# CITY OF ALBUQUERQUE

PLANNING DEPARTMENT – Development Review Services

**RE: Gutierrez Trucking Maintenance Facility  
3006 Todos Santos St. NW  
Grading & Drainage Plan  
Engineer's Stamp Date 8-20-2015 (File: G10D036)**

Based upon the information provided in your submittal received 8-24-15, the above referenced plan cannot be approved for action by the DRB on the Site Plan for Building Permit or Building Permit until the following comments are addressed:

GRADING & DRAINAGE PLAN
Scale 1"=20'-0"

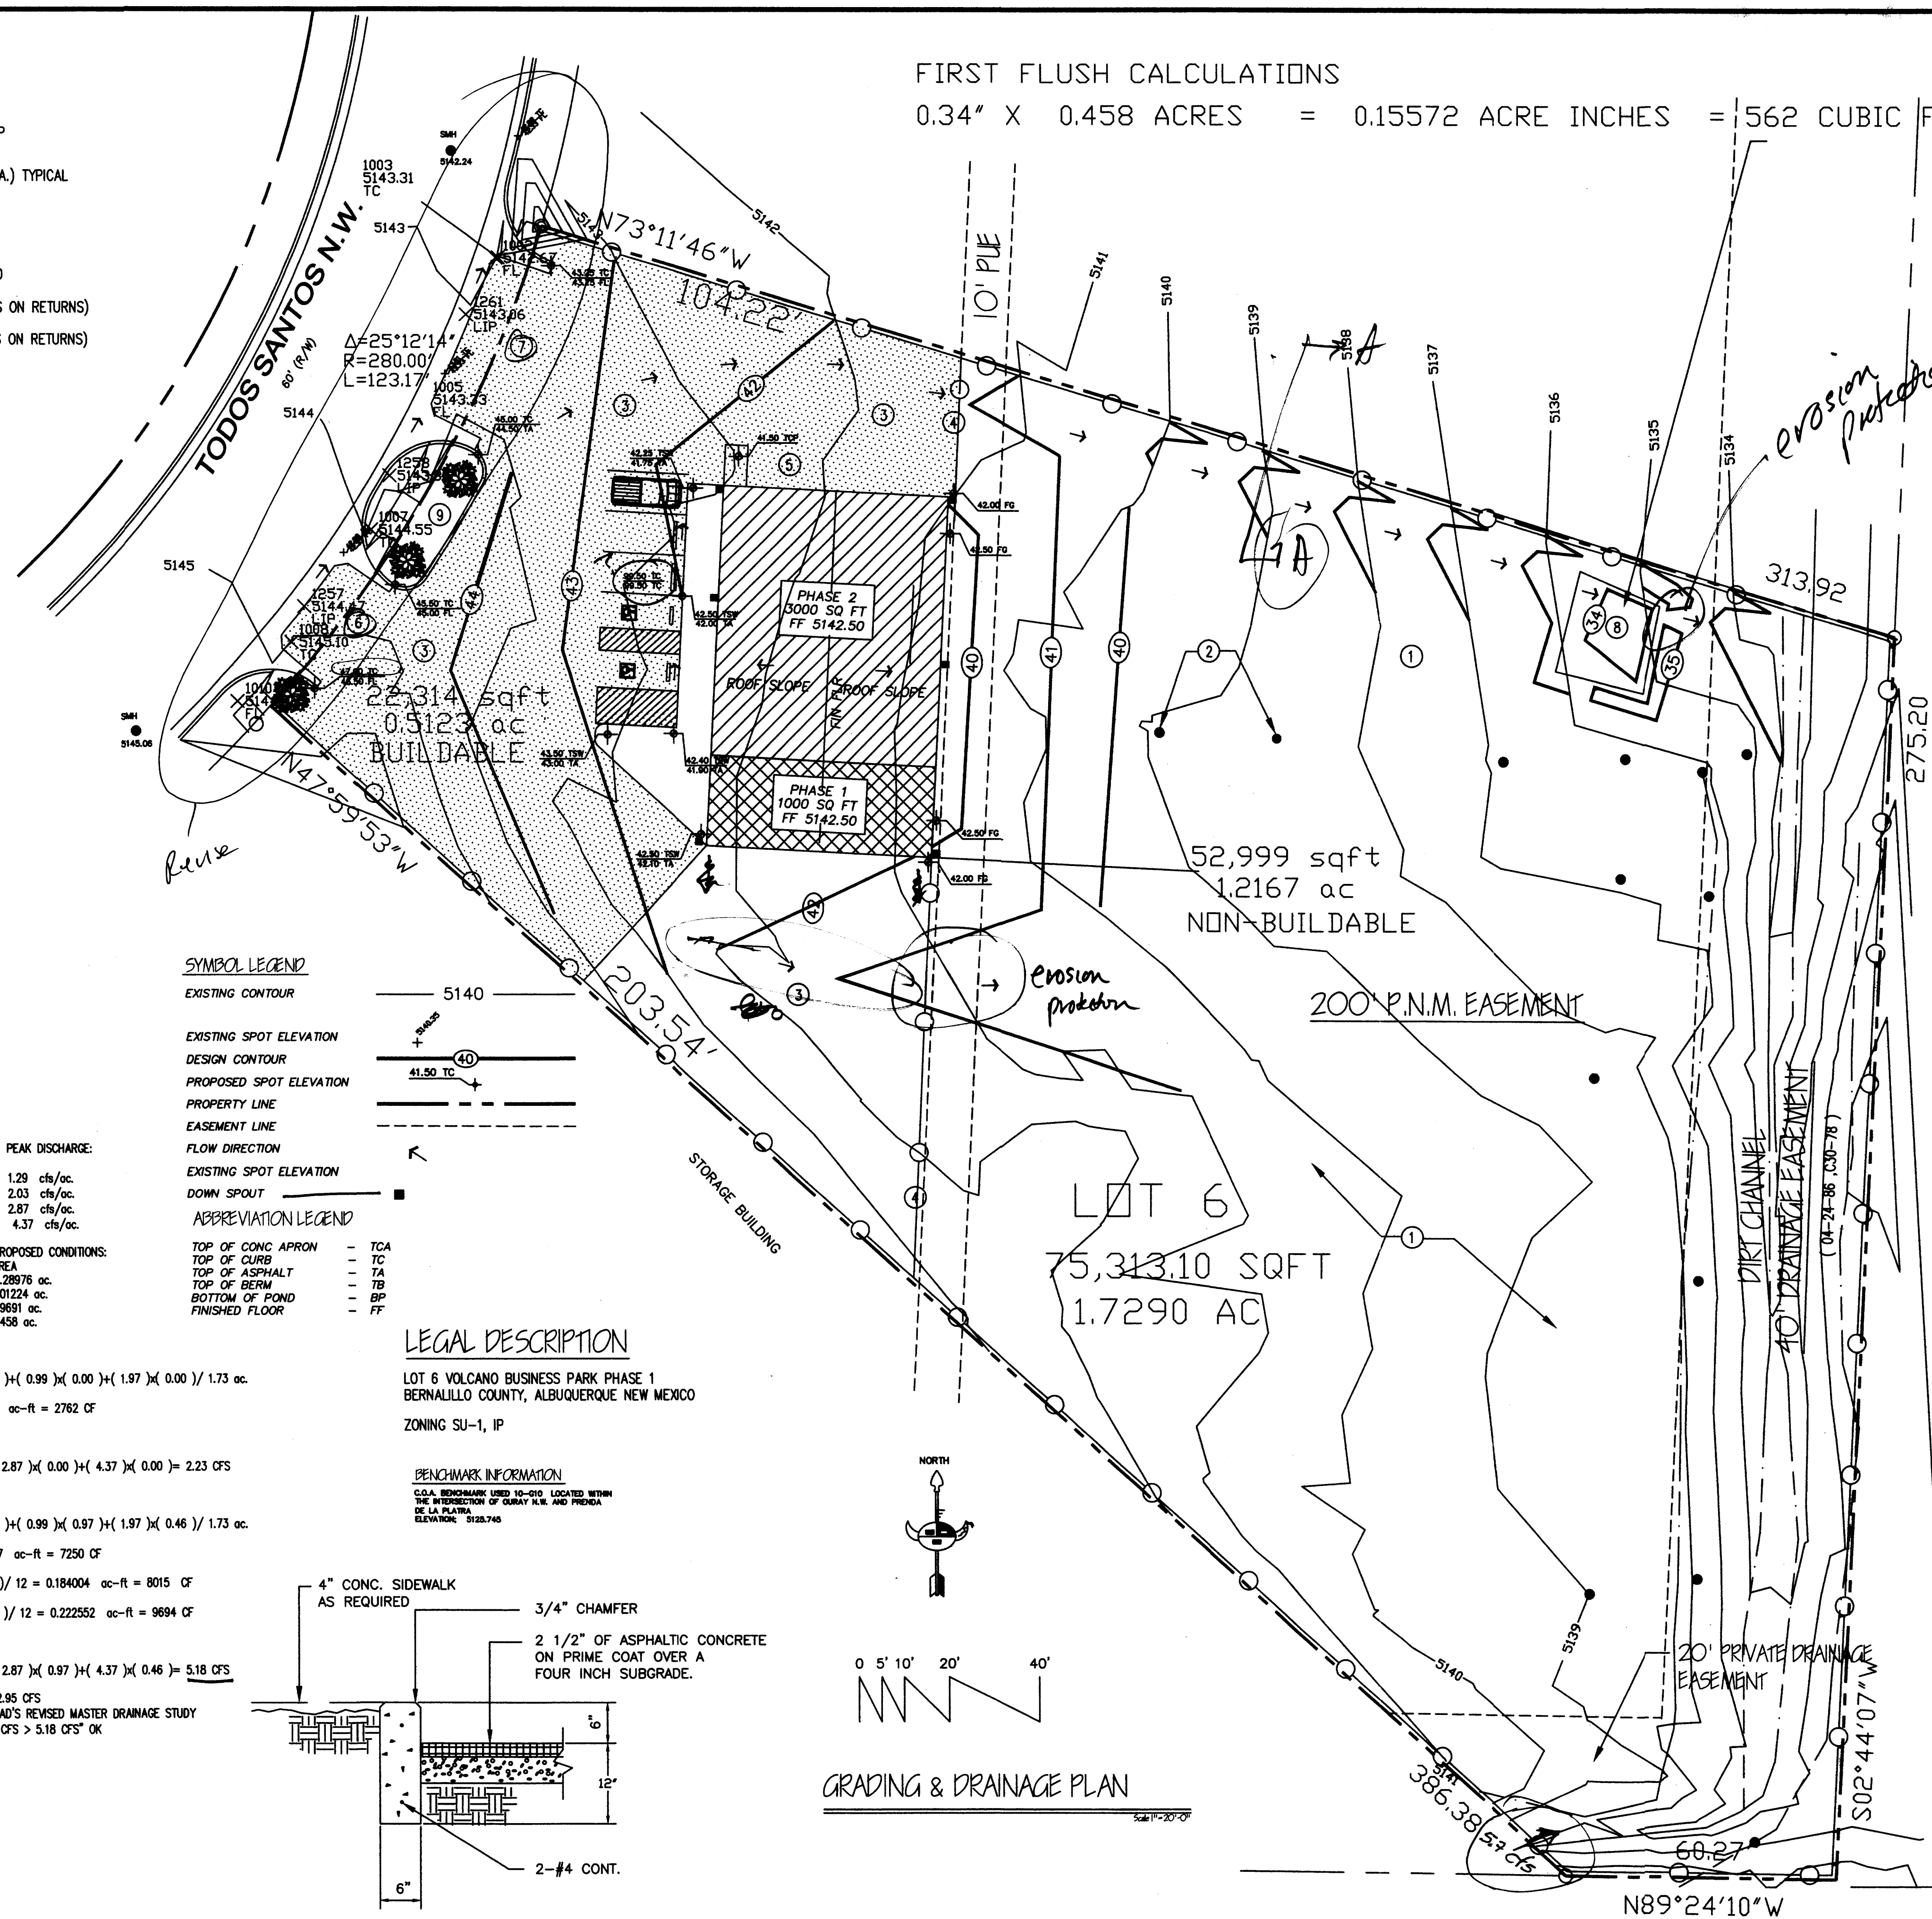
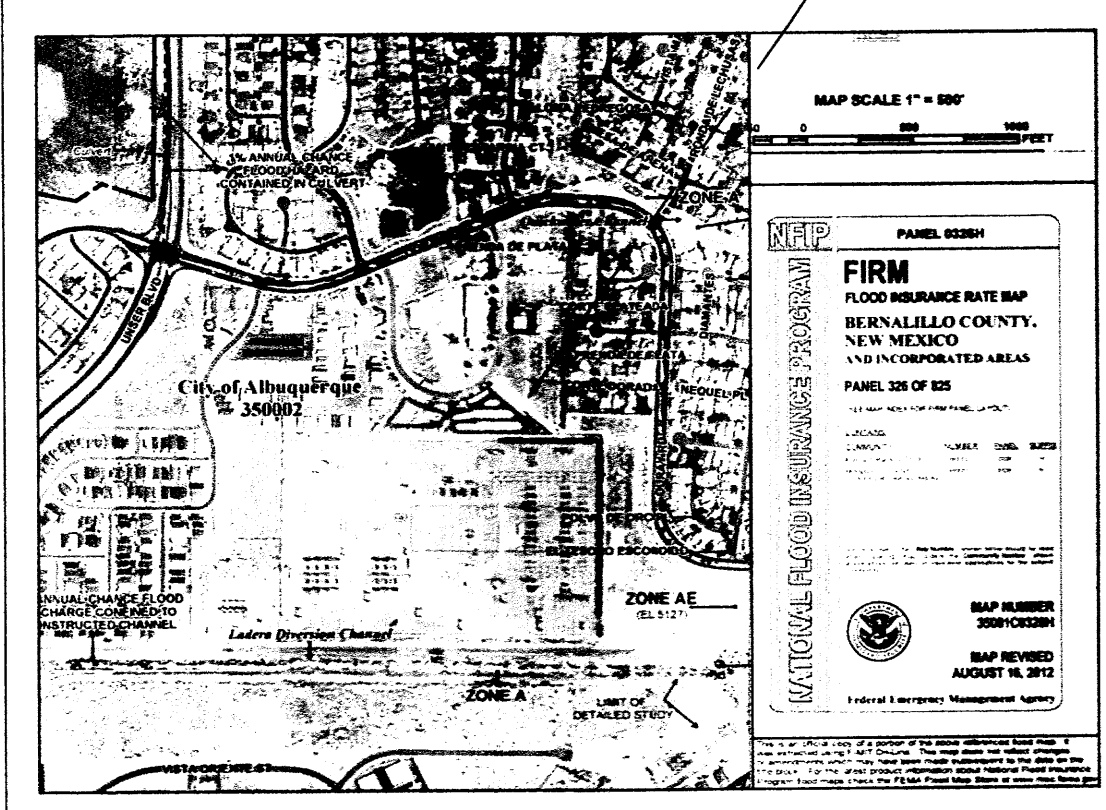
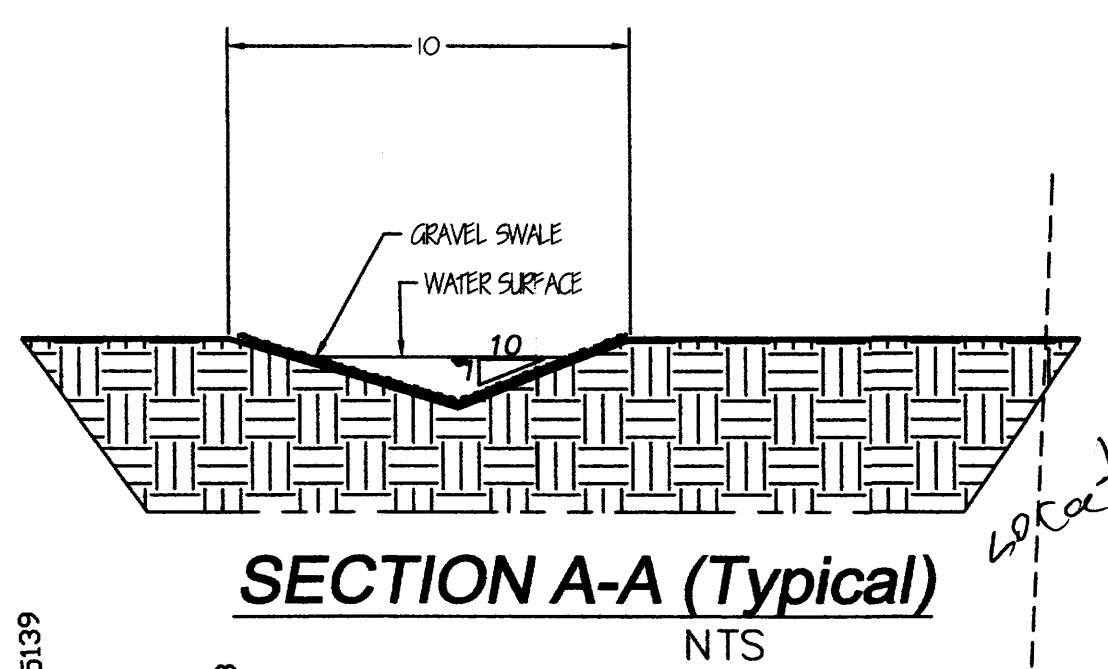
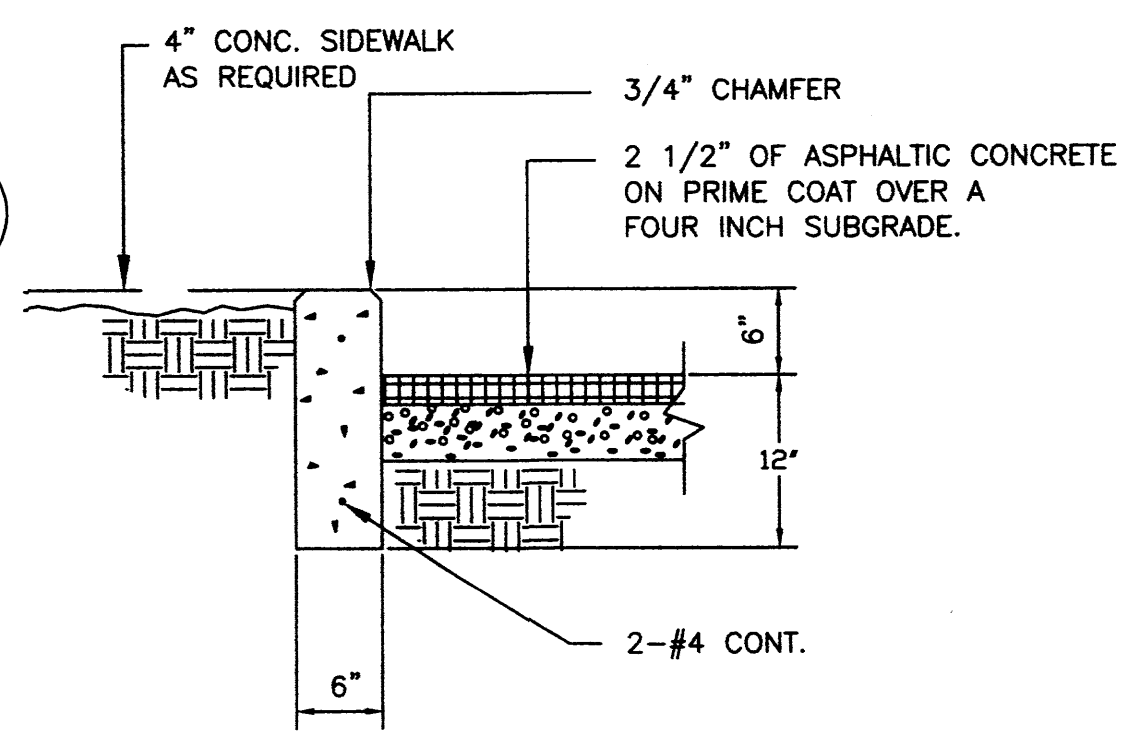
- 1) Narrative indicates this is a 2-phased project. Clearly show what is to be built in Phase I and what is to be built in Phase 2.
- 2) Regarding the 1<sup>st</sup> comment, show or state how drainage will be managed in Phase 1, before full build out and also for Phase 2 or full build-out.
- 3) Show with flow arrows the intended direction of the roof discharge.
- 4) Revise narrative regarding offsite flows. Drainage files G10D29D and G10D29F show that 5.7 cfs flow thru this site. Excerpt provided appears to have an error.
- 5) Per the City's MS4 Permit with EPA all sites must manage the "First Flush" onsite. Provide a first flush pond.
- 6) First flush can be calculated using  $0.44'' - 0.10''$  (initial abstraction) =  $0.34''$
- 7) Show Key notes 6 & 7 for the driveways on the plan

- 8) Flow line elevations in Todos Santos, and all curb return data.
- 9) Show water blocks and provide elevations
- 10) Show that all landscaping is depressed.
- 11) Since the disturbed area on this site exceeds 1.0 acre, an Erosion and Sediment Control (ESC) Plan, prepared by a NM PE and approved by the City's Stormwater Engineer, will be required for this site
